Application for Removal or Variation of a Condition following Grant of Planning Permission or
Listed Building Consent

Class Q (Agricultural Buildings to Class C3 Dwellinghouses) of Part 3 of Schedule 2 of the Town and Country Planning (England) (General Permitted Development) Order 2015

3/2024/0198

Proposed Ground Floor Plan
Scale (1:50)

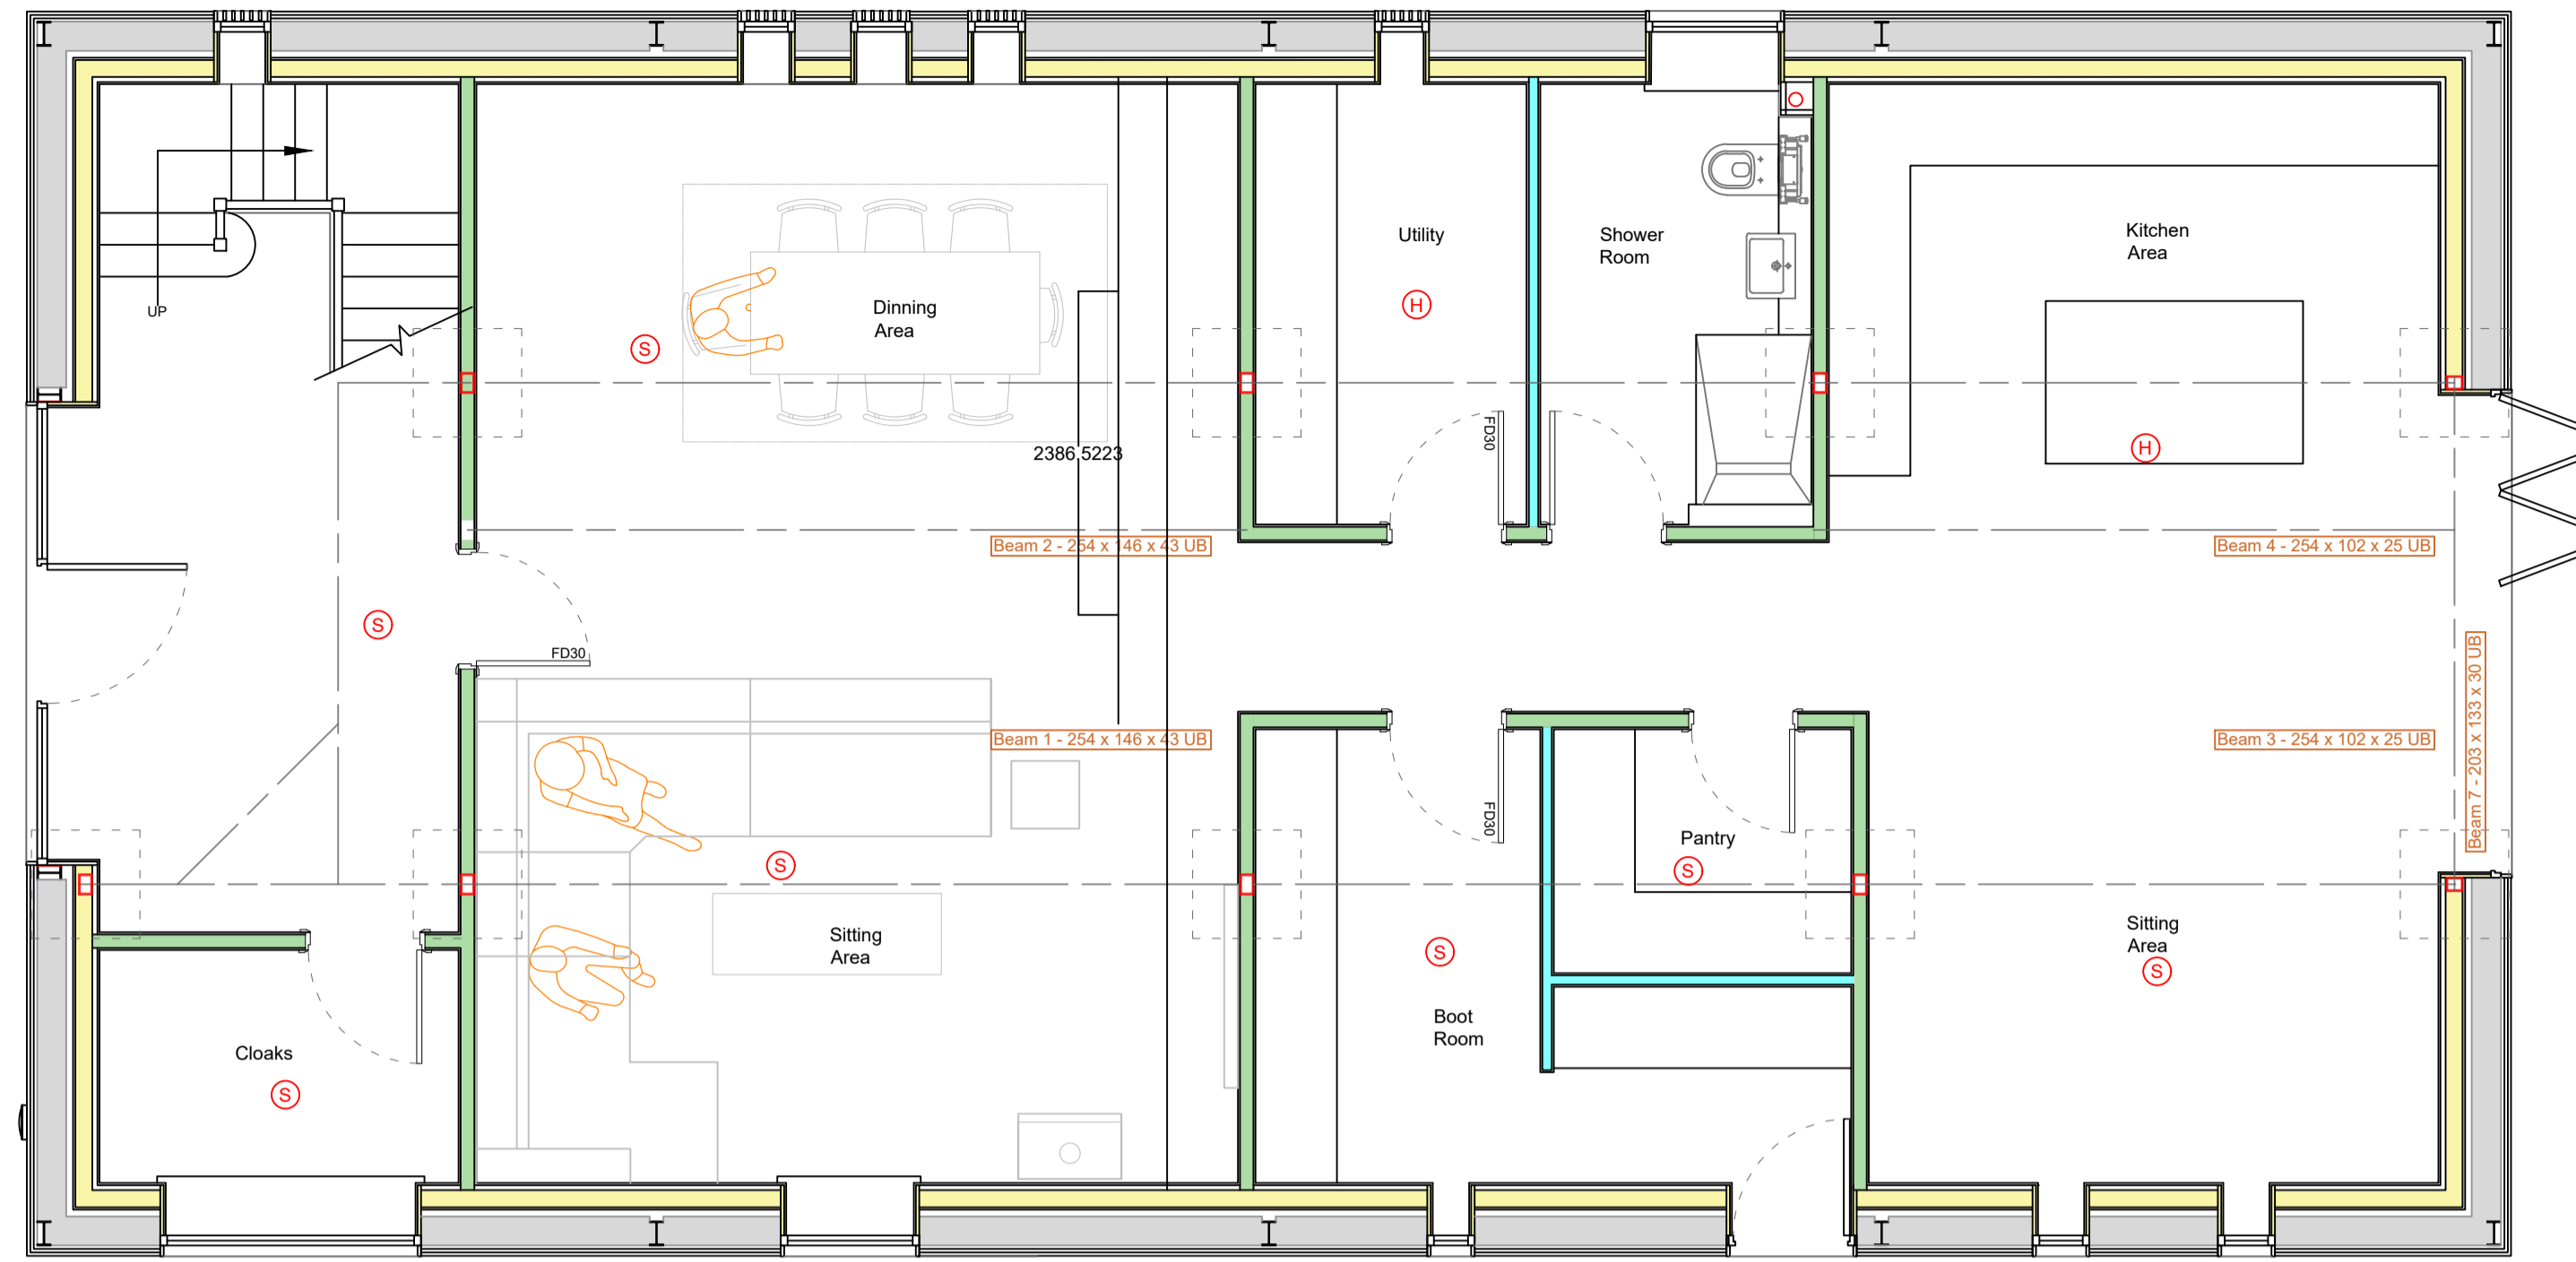
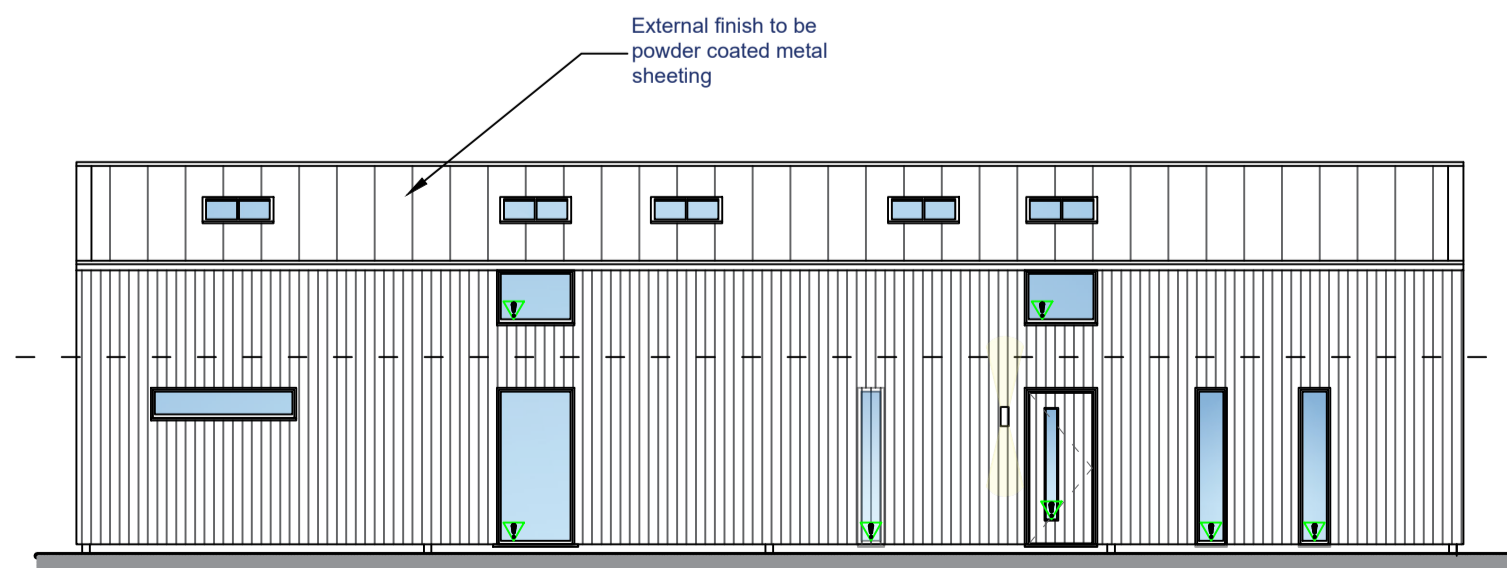
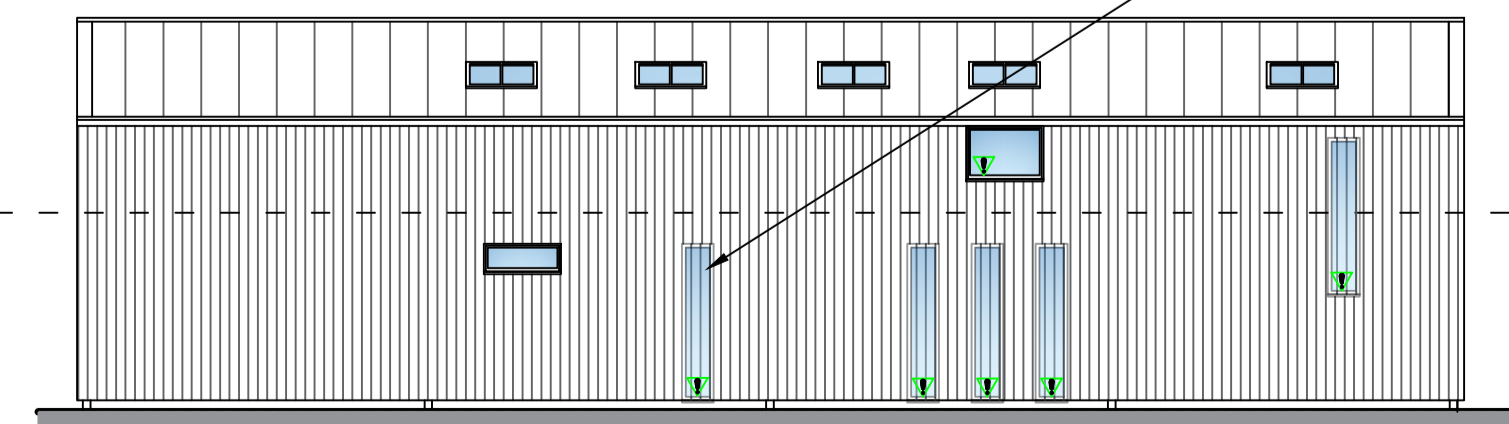
We would like to substitute plan 001 - Proposed Plan with the new plan 001 - Proposed Plan - Rev C as this plan has two additional windows in the southeast elevation to the siting area.

We would like to change the windows from being timber windows to powder coated aluminium windows. The proposed conversion is for a portal frame steel barn conversion not a traditional stone building. the current building and the surrounding agricultural buildings have steel doors/openings so it would be more sympathetic to use powder coated aluminium. In addition timber windows are a require much greater maintenance and have bulker frames which will have an overbearing impact on the gable elevations.

Condition 2 to read - The development shall be carried out in accordance with the plans submitted with the prior approval application (001 Proposed Plan Rev C).

Condition 14 to read - All doors and windows indicated on the submitted/approved plans shall be in powder coated aluminium and retained as such in perpetuity
